City of Albuquerque

RE: REVISED-ENGINEER CERTIFICATION FOR FUSION, INC. (M15-D23D)
CERTIFICATION STATEMENT DATED 9/24/92.

RE: ENGINEER CERTIFICATION FOR FUSION, INC. (M-15/D23D) CERTIFICATION
STATEMENT DATED SEPTEMBER 7, 1992

TEMPORARY ASPHALT RUNDOWN DETAIL
N.T.S.

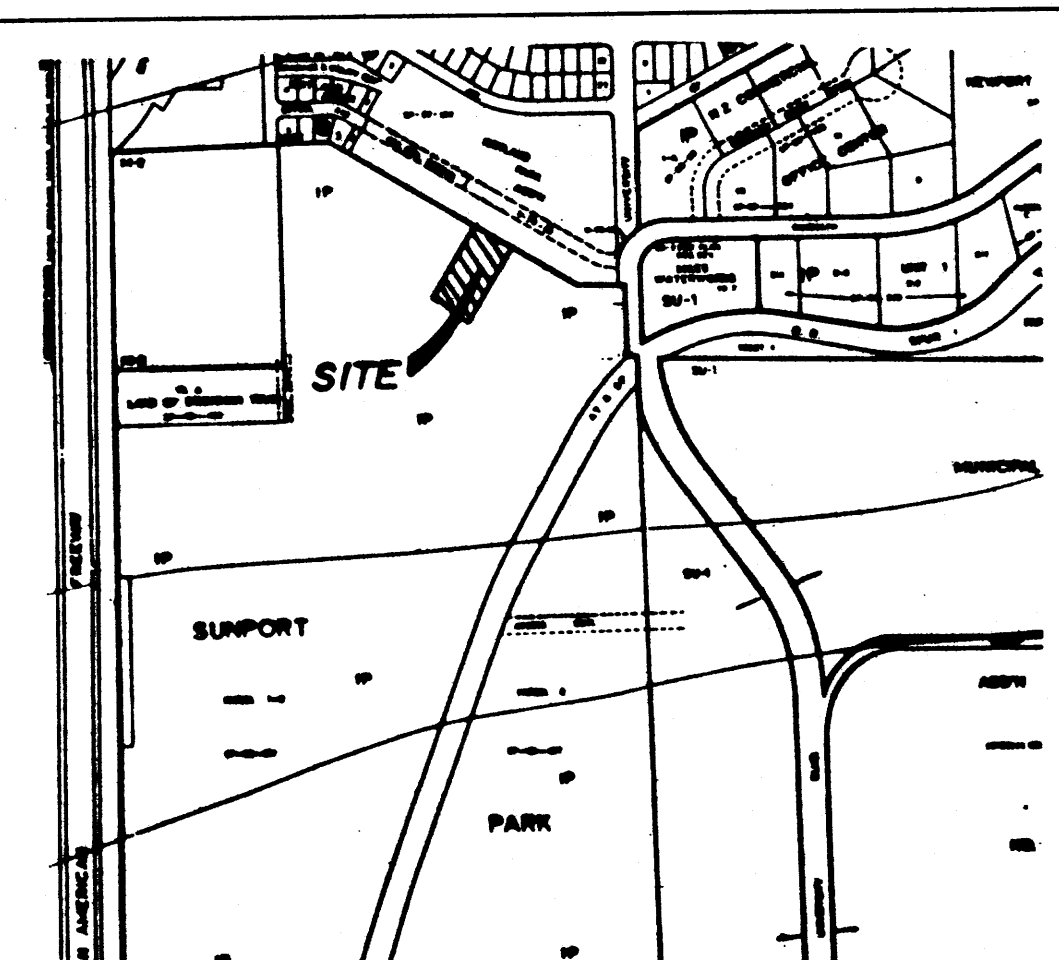
1. Swale on the east side of the property which intercepts the off-site flows is not adequate to handle the flows. A field survey indicated that there exists a low point within the berm which will allow the runoff to be routed towards the west and not the asphalt rundown.
2. Large erosion cuts are evident on the north side from the downspout. The erosion problem must be addressed.
3. Downspout on the northwest corner of building has already caused erosion and sediment onto the swale along the west side of the building.
4. Original approved plan indicates a wall on the northeast corner of the building, wall does not exist.
